Great Yarmouth Third River Crossing Order 202[*]

Document NCC/GY3RC/EX/059: Consultation Report on the Proposed Non- Material Changes to the Application

Author: Norfolk County Council

Date: 28 January 2020

DRAWING NUMBER
GYTRC-NCC-HGN-XX-DR-CB-1010

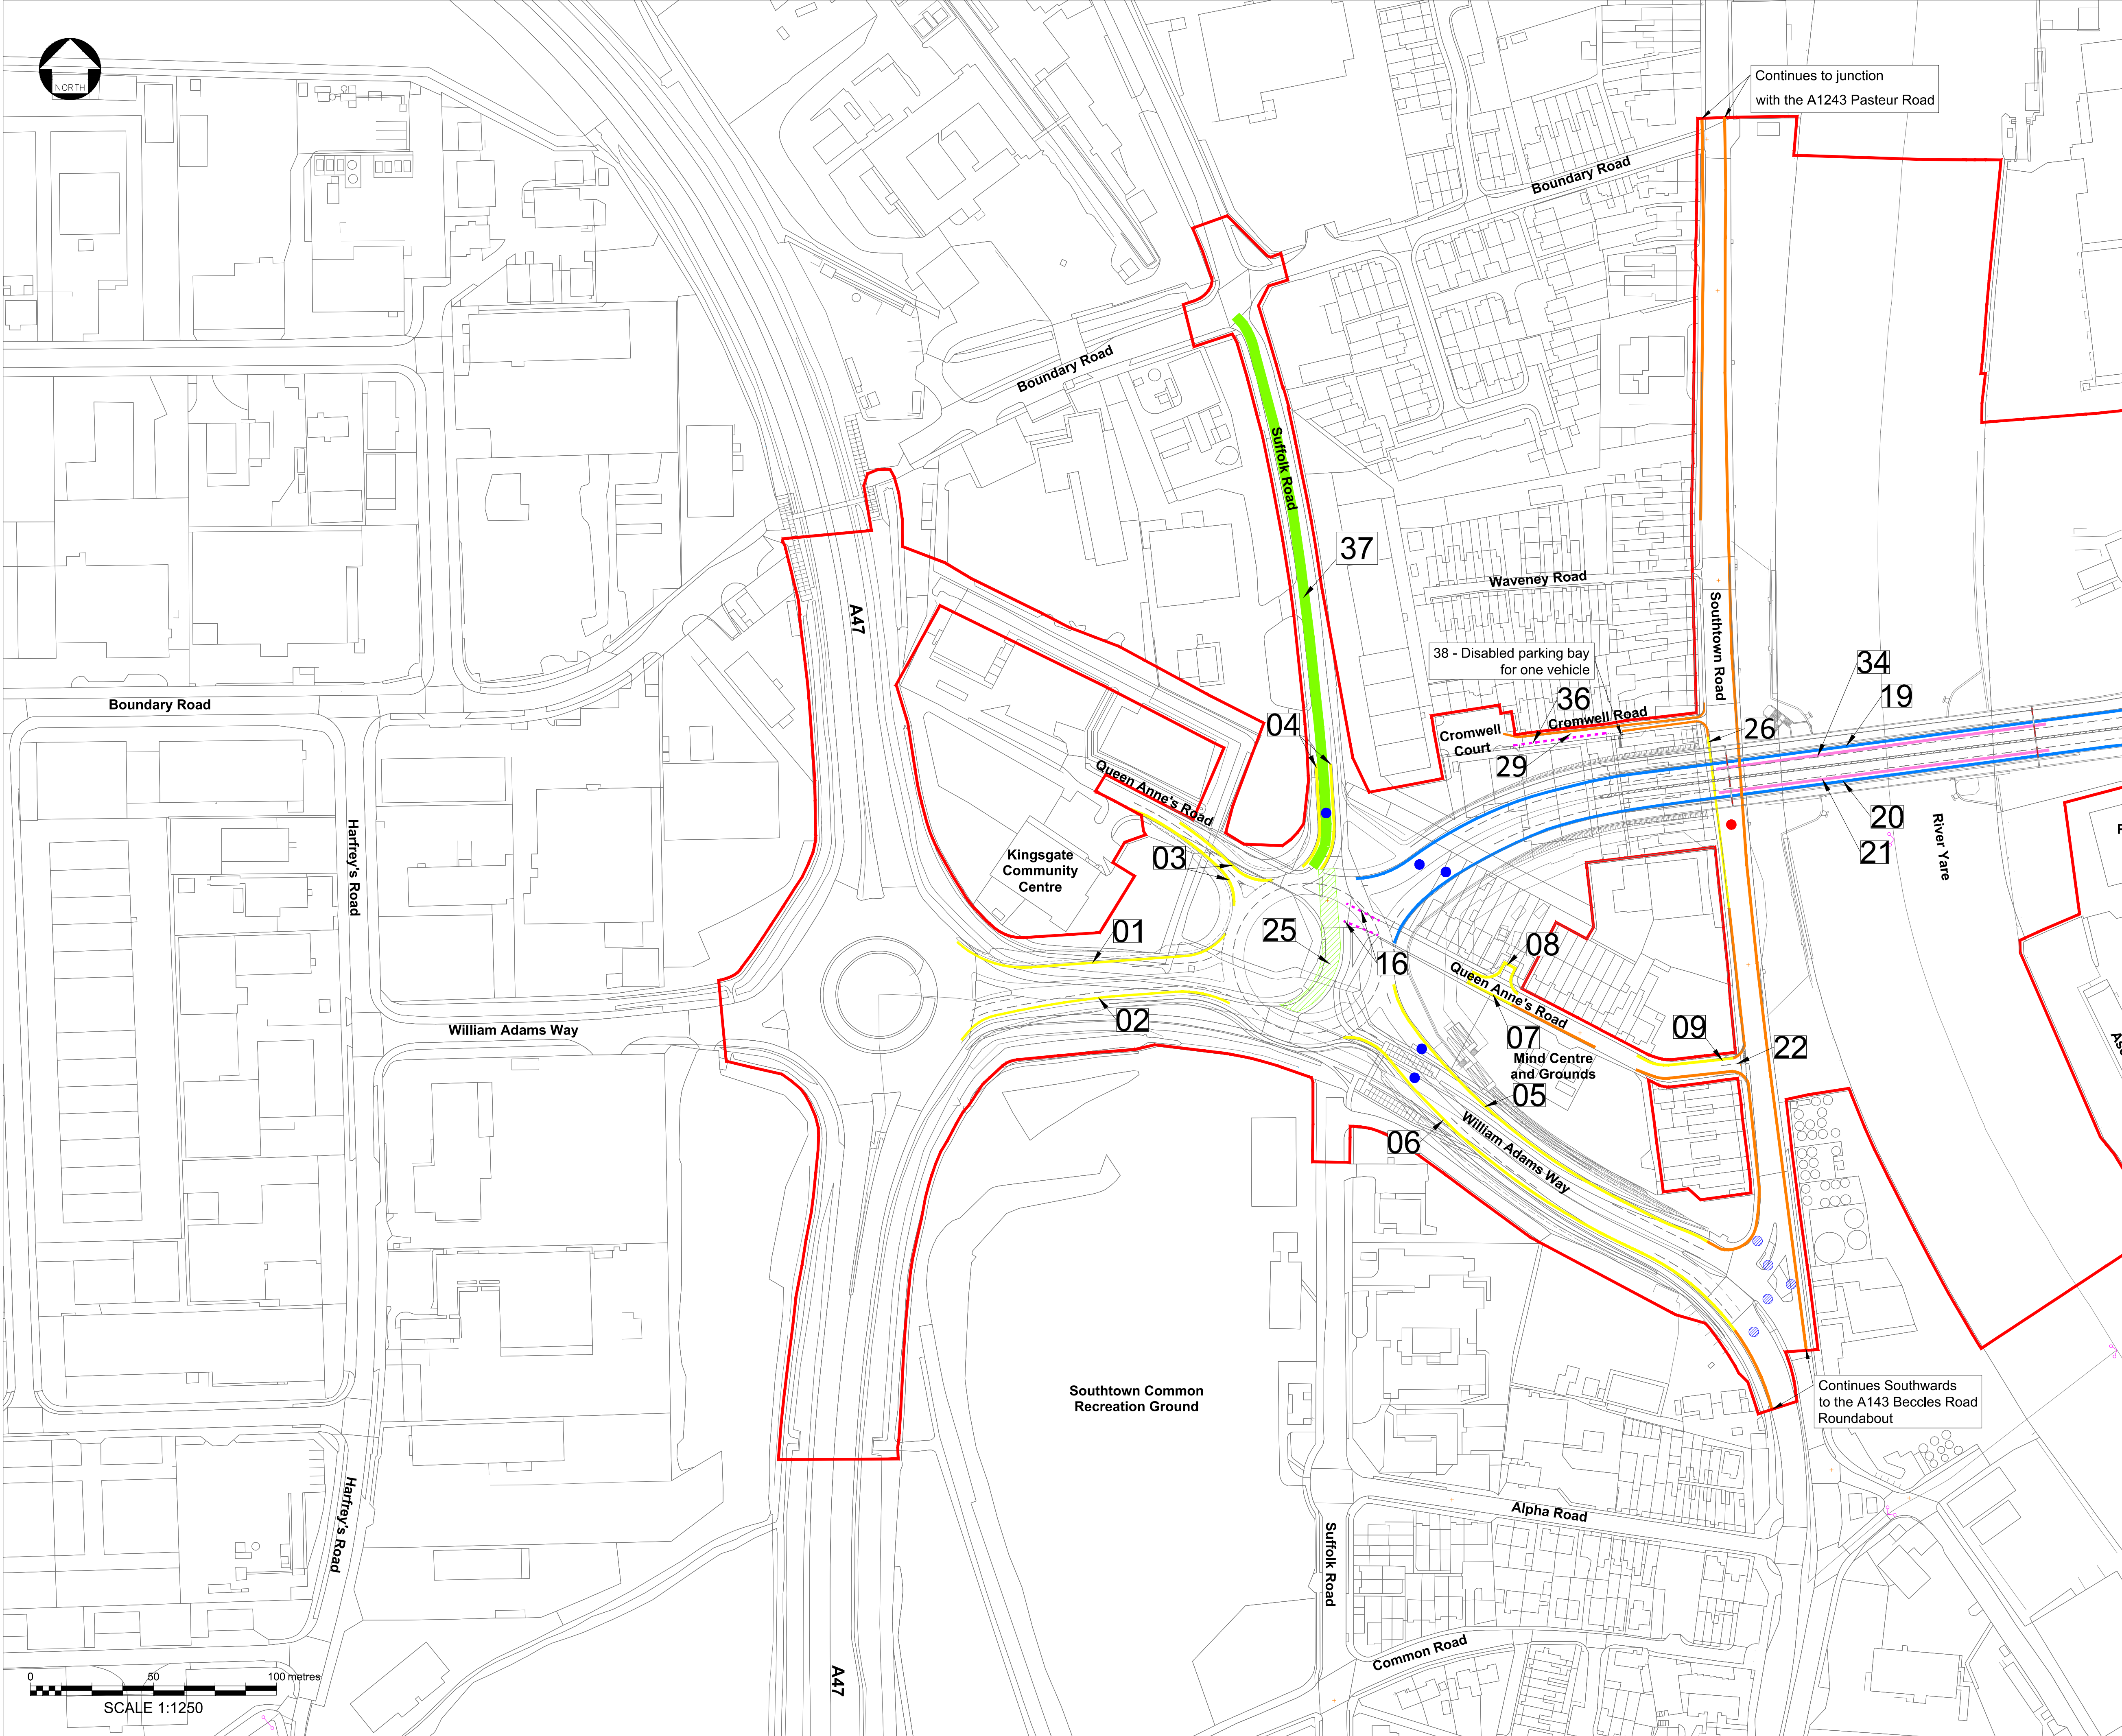
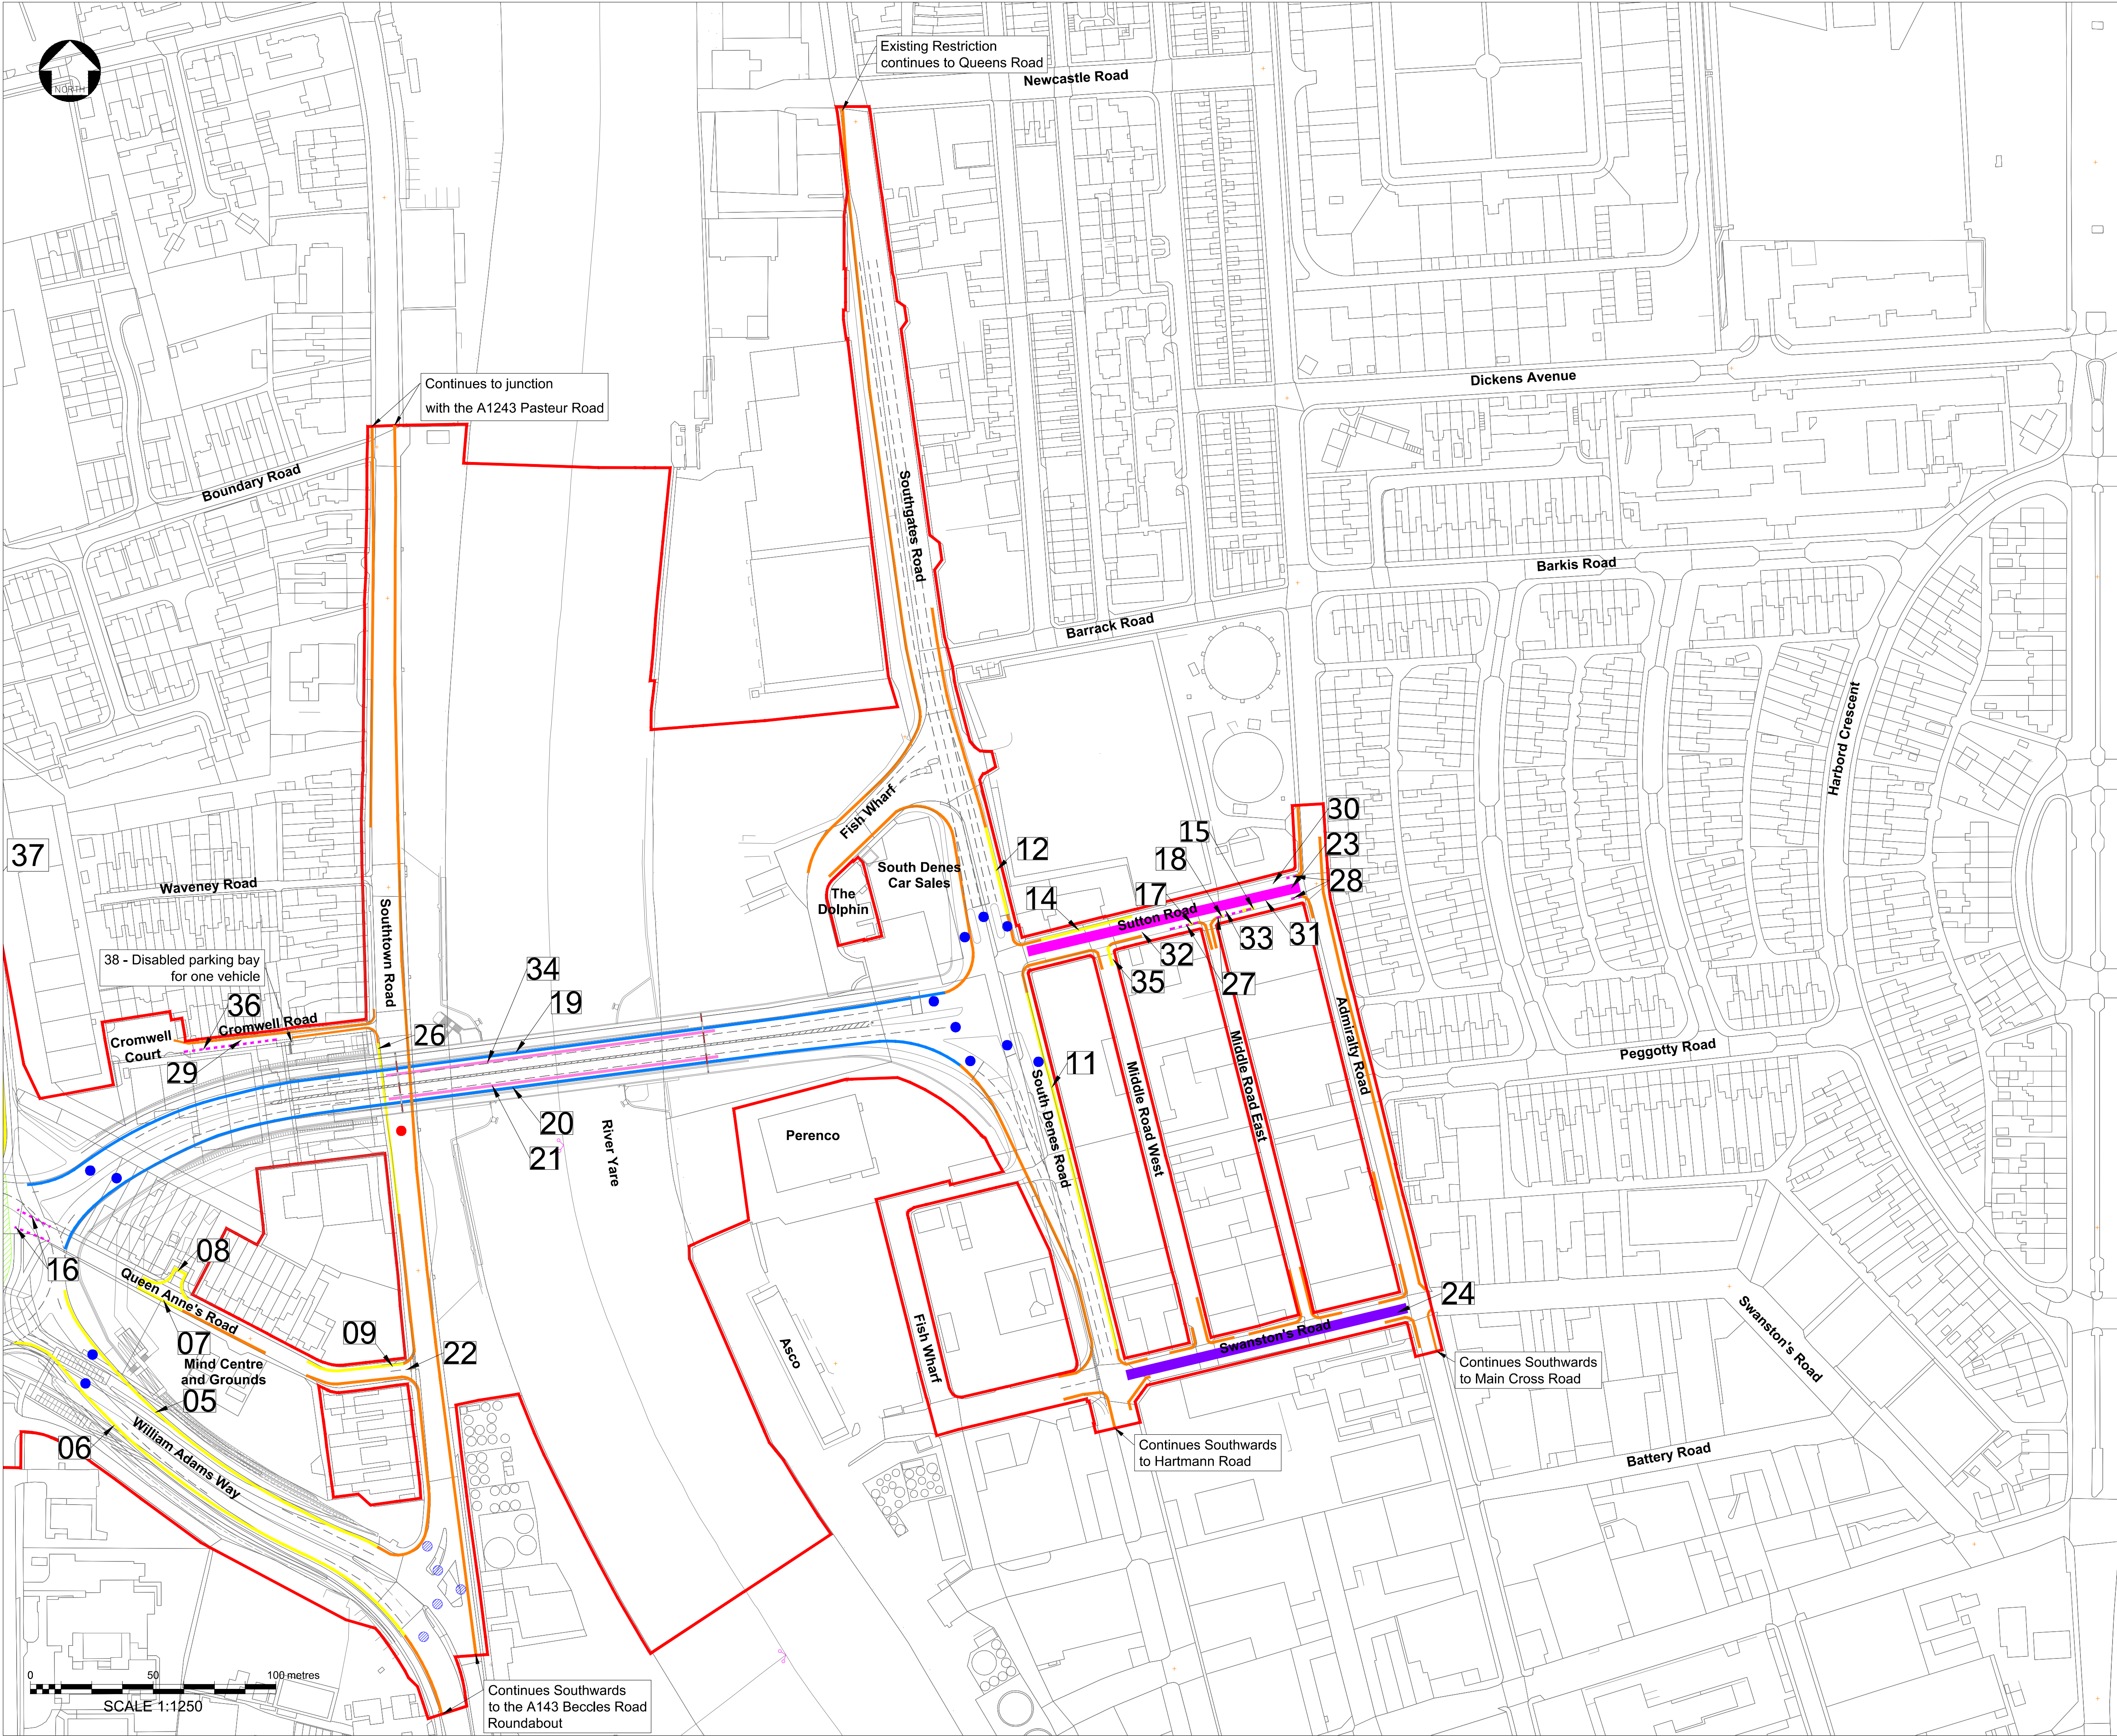
- Removal of the 'no waiting at any time' restriction proposed in the DCO Application (identified as Traffic Regulation Measure Reference Number 10 on the Traffic Regulation Measures Plans, on Sheet 2 of 2 (Document Reference 2.3, Planning Inspectorate Reference APP-008)) on the east side of A1243 Southgates Road from a point 21 metres north of the midpoint of its junction with the U60757 Barrack Road northwards for a distance of 50 metres;

- Removal of the limited waiting Monday to Saturday between 8am and 6pm (1 hour maximum waiting period, no return within 2 hours) restriction proposed in the DCO Application (identified as Traffic Regulation Measure Reference Number 13 on the Traffic Regulation Measures Plans, on Sheet 2 of 2 (Document Reference 2.3, Planning Inspectorate Reference APP-008)) on the east side of A1243 Southgates Road from a point 71 metres north of the mid-point of its junction with the U60757 Barrack Road northwards for a distance of 27 metres.

- Reduction by 20 metres at its western end of the no waiting at any time restriction proposed in the DCO Application on the north side of U61067 Queen Anne's Road from its junction with the new roundabout to a point 65 metres north west of that junction.

- The provision of a 6.6 metres long disabled parking bay (available at all times) to be located at the western end of the proposed parking bays which are proposed in the DCO Application to be provided along the southern side of Cromwell Road.
